Rezoning Transportation Analysis

Petition Number: 2021-080

Revision Log:

Date	Description
08-02-2021	First Review (KP)
08-23-2021	Second Review (KP)
09-28-2021	Third Review (BB)

PROJECT NO.	MRE-13040
FILENAME:	
DESIGNED BY:	BGP
DRAWN BY:	BGP
SCALE:	
DATE:	12-15-2017
SHEET NO.:	RZ-1

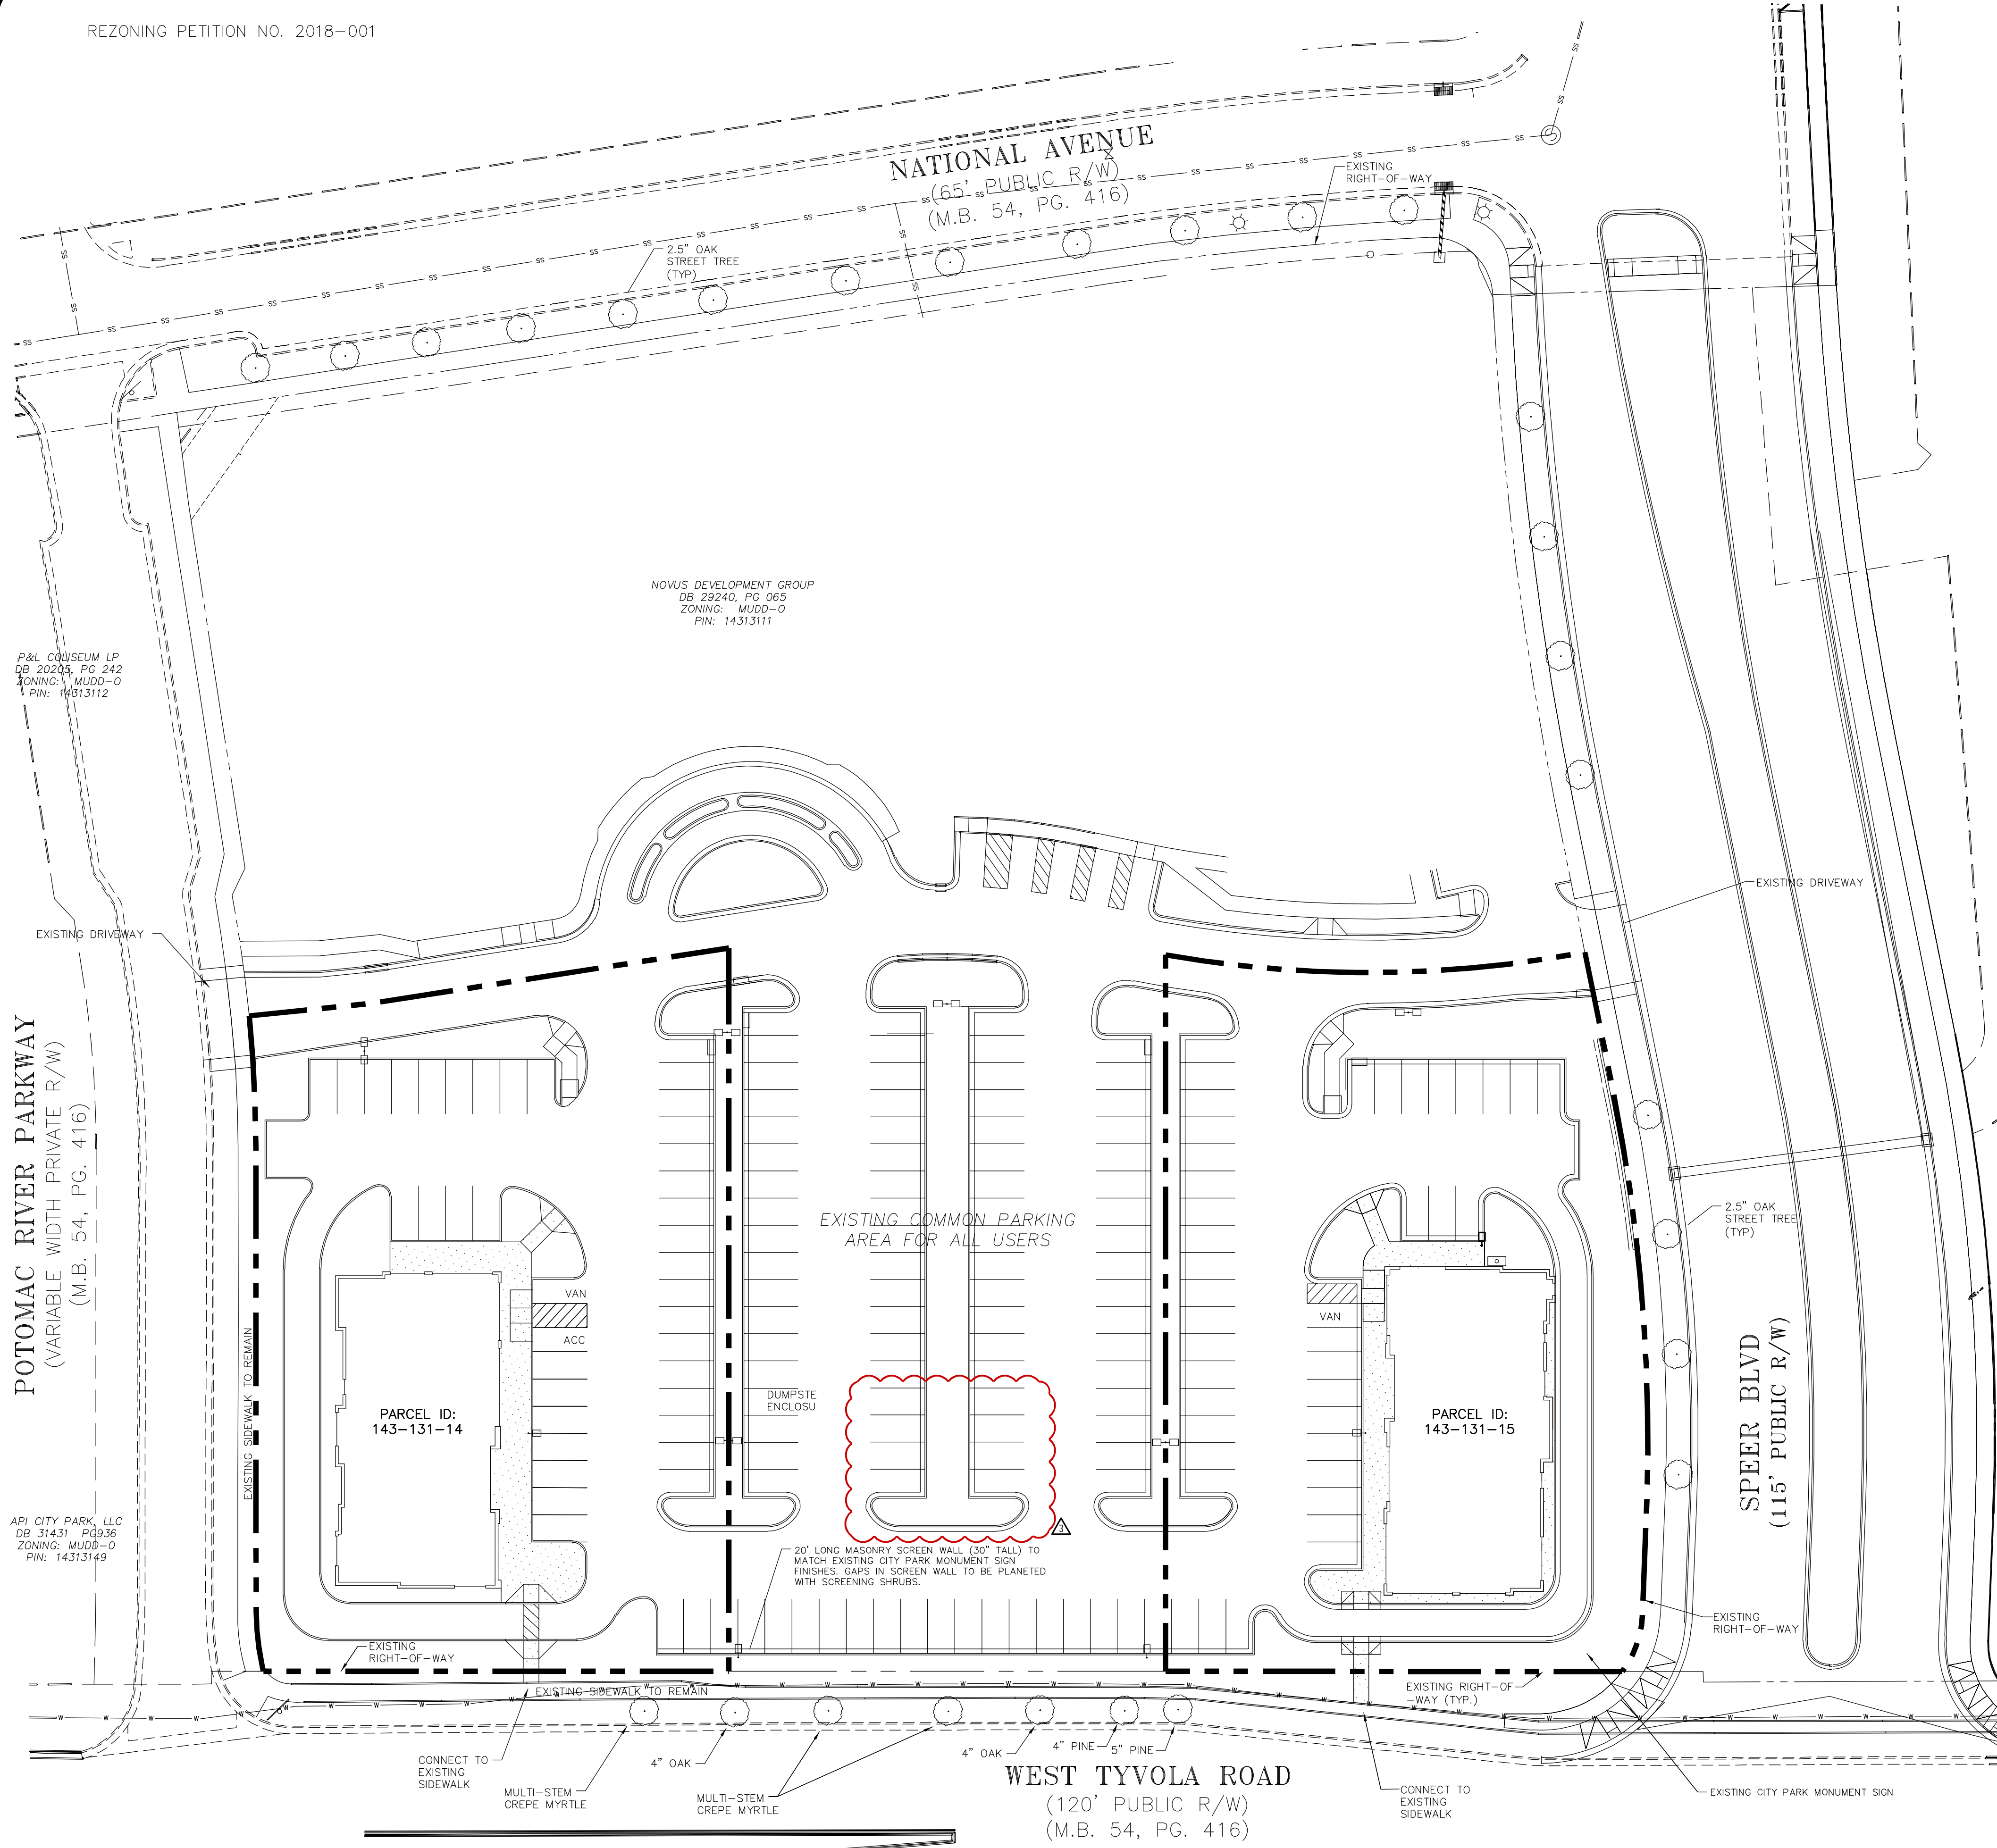
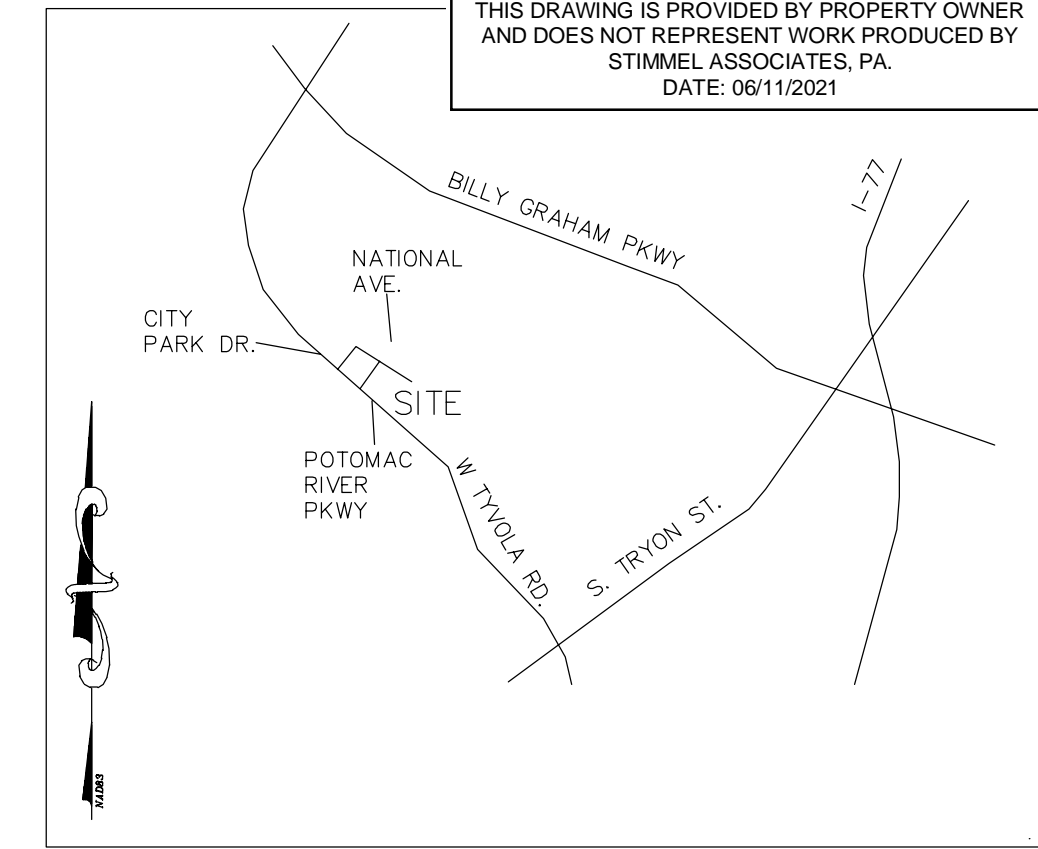
2. ~~Revise rezoning sheet RZ-1 to accurately reflect the existing striping on Speer Boulevard and removing the traffic signal at the intersection of Speer Boulevard and Tyvola Road.~~
